## **Letter to the Applicant from National**

11 July 2022

**Ref: SUNNICA ENERGY FARM**

**Sheet 21 of 24**

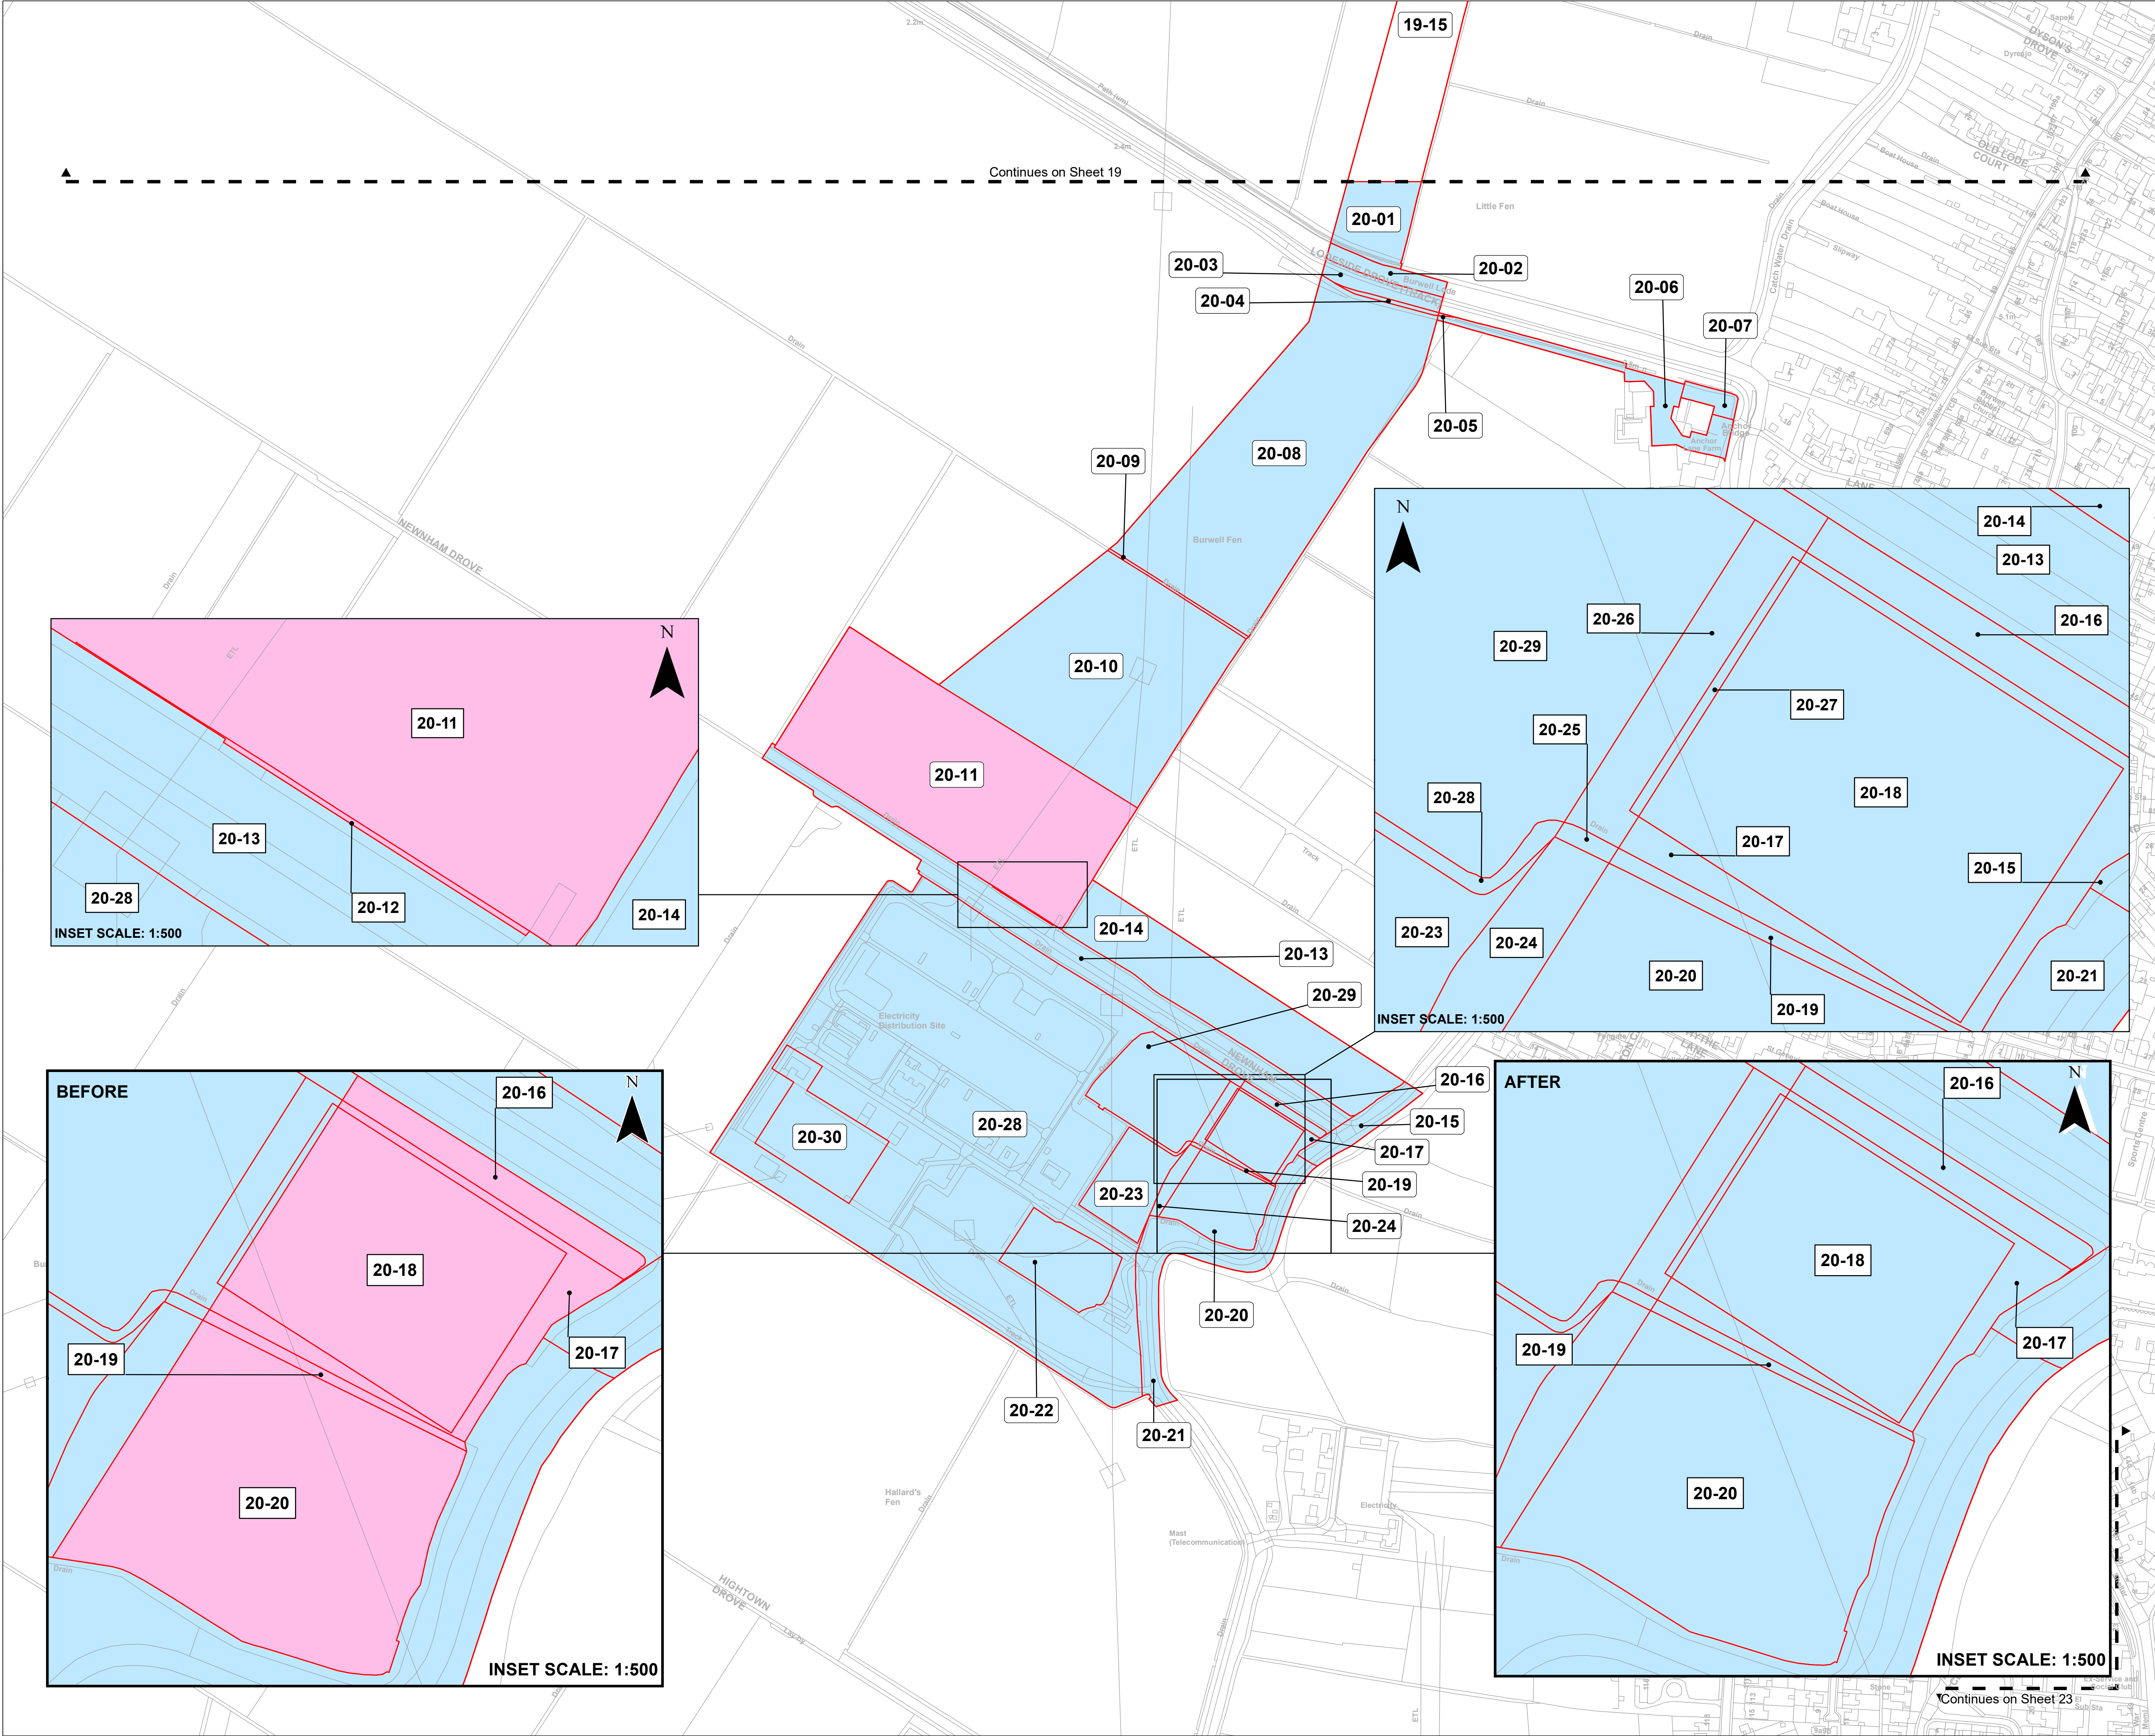
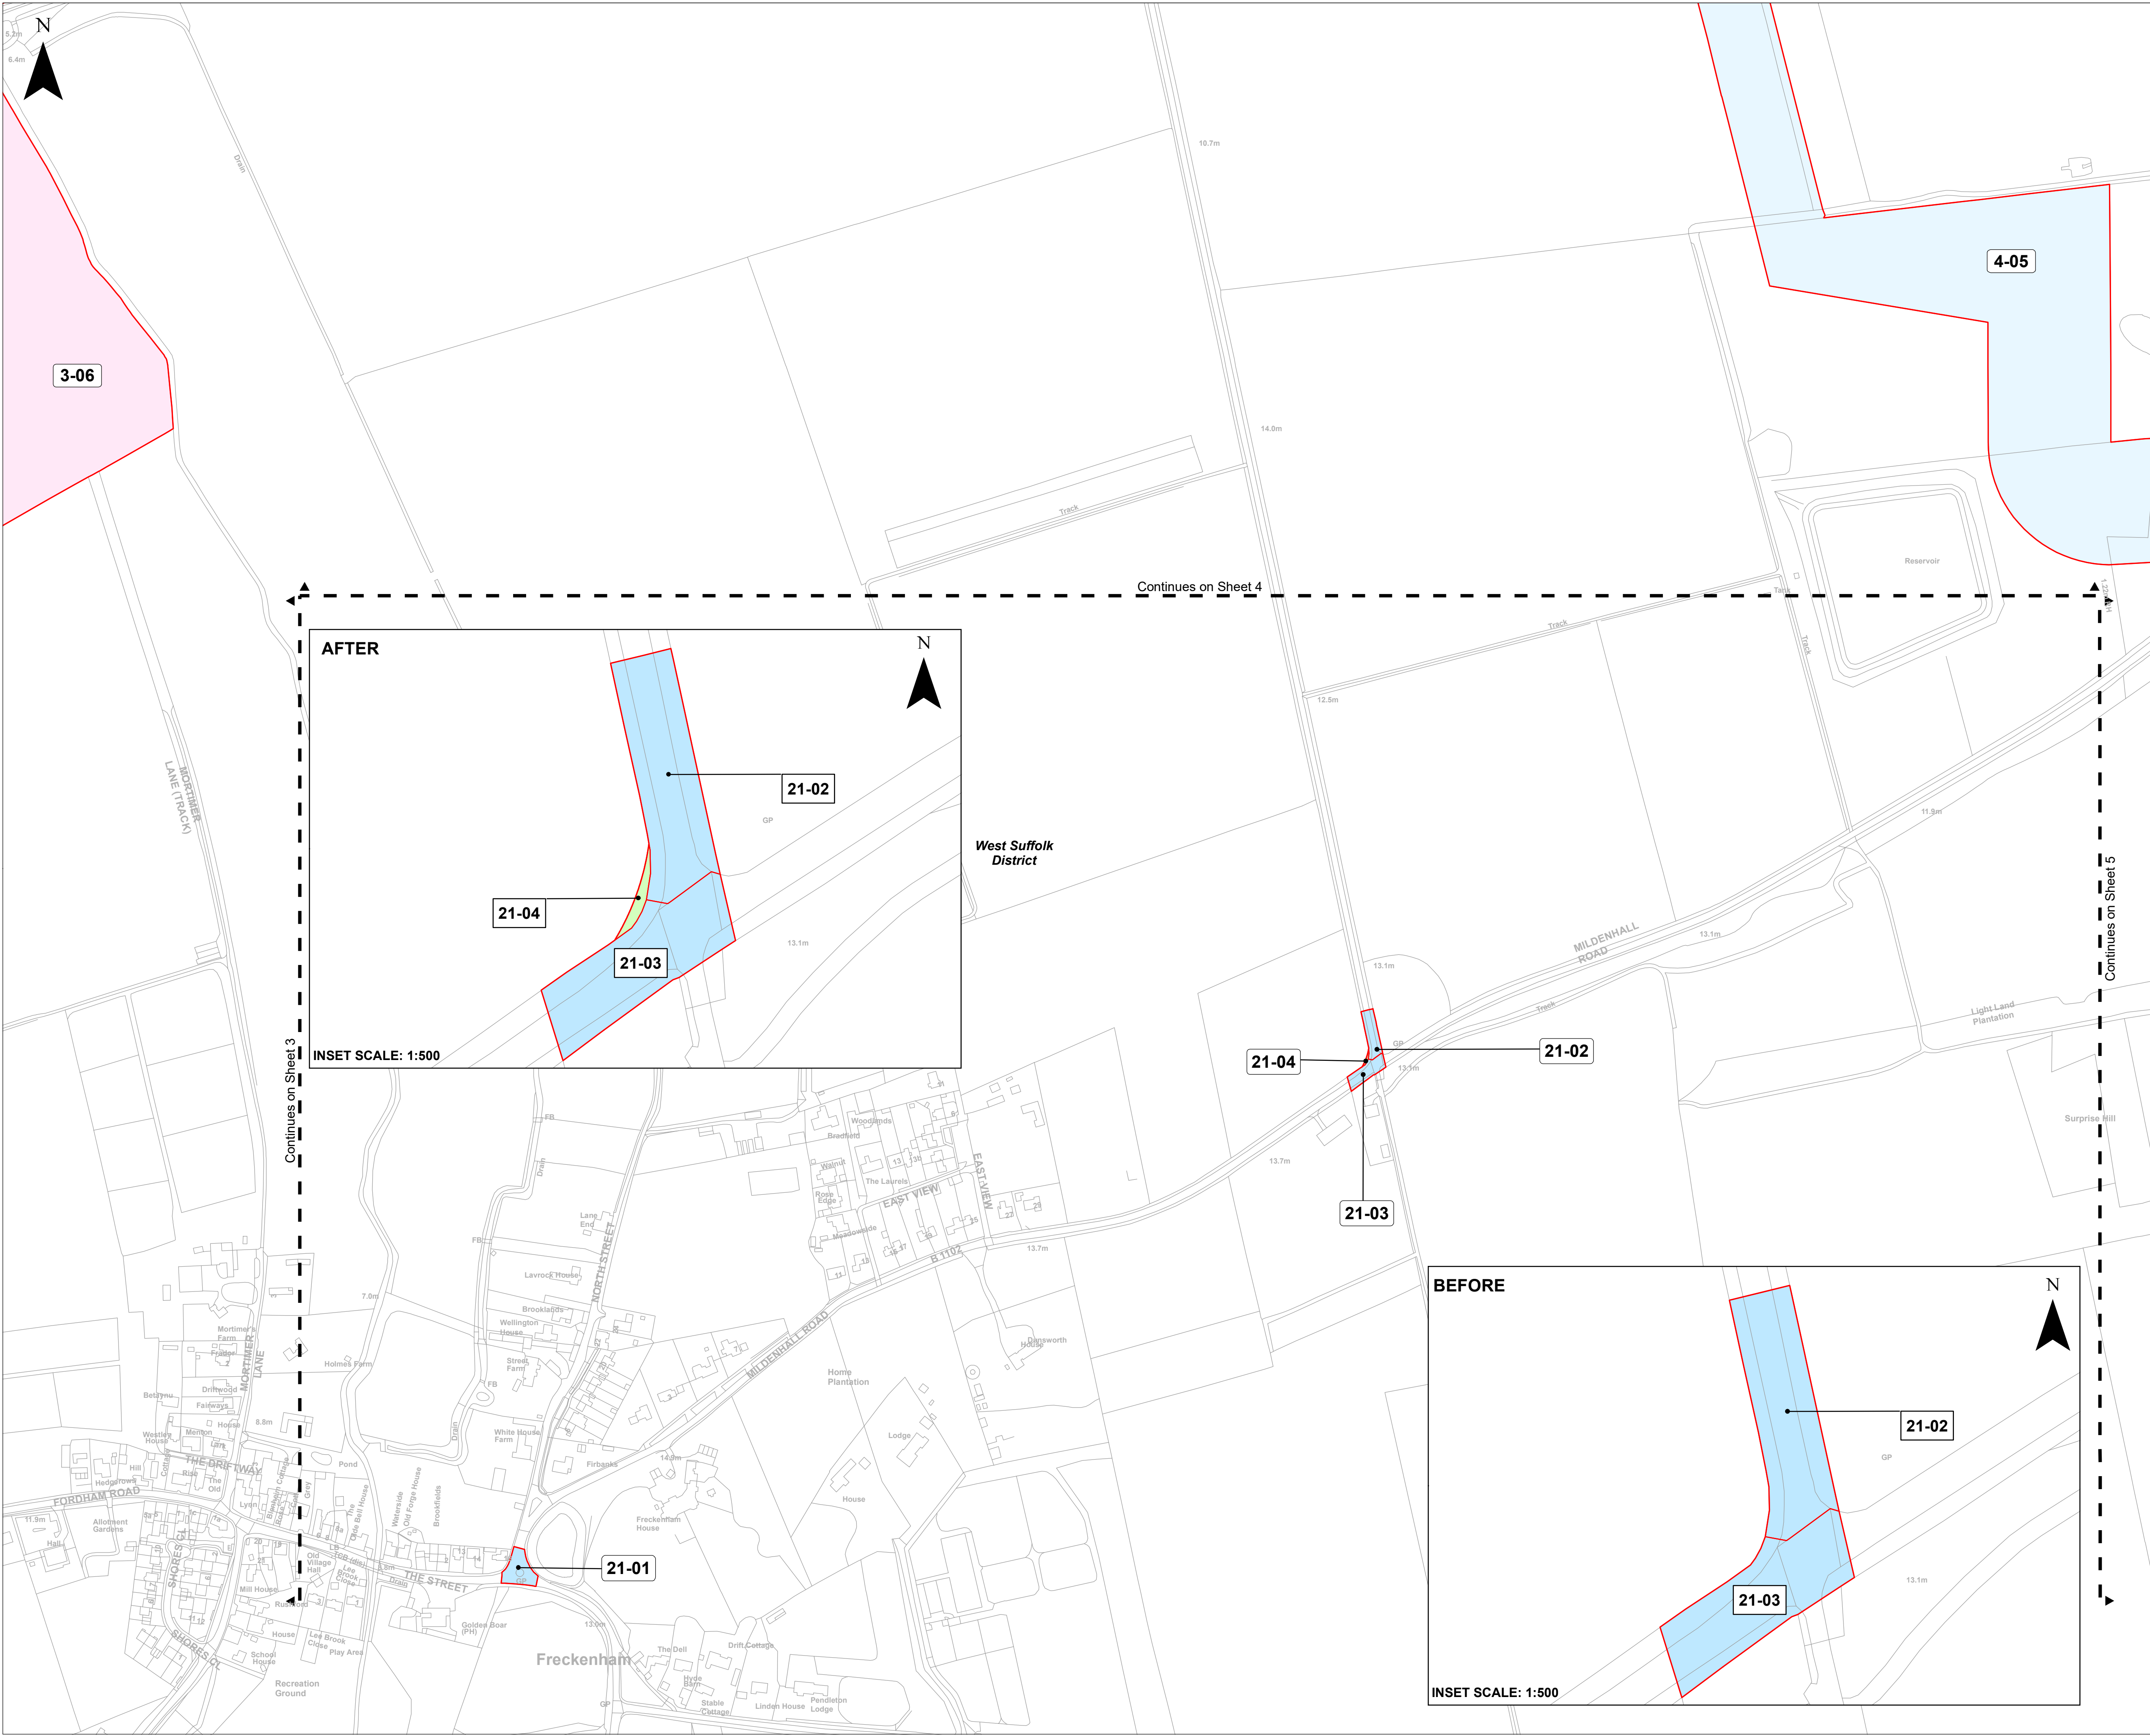
As part of the feasibility process, NGET reviewed the submitted DCO documents, including the proposed plans for the Option 1 connection. In undertaking this review and in the context of NGET's statutory obligations, NGET concluded that unfortunately a connection at Option 1 would not be technically feasible.

- that the land requested by Sunnica for their substation to be provided pursuant to the DCO was larger than originally discussed between NGET and Sunnica; and
- In addition, NGET must meet requirements to provide other connections at the Burwell Main Substation site. To facilitate this, as Sunnica is aware, NGET is undertaking an extension of the substation. the land required for this will mean that the Option 1 connection is not possible.

The correct reference for option 1 is Land Plots 20-16, 20-17, 20-18, 20-19, 20-20 as shown on the Land and Crown Plans [rev1] (AS003).
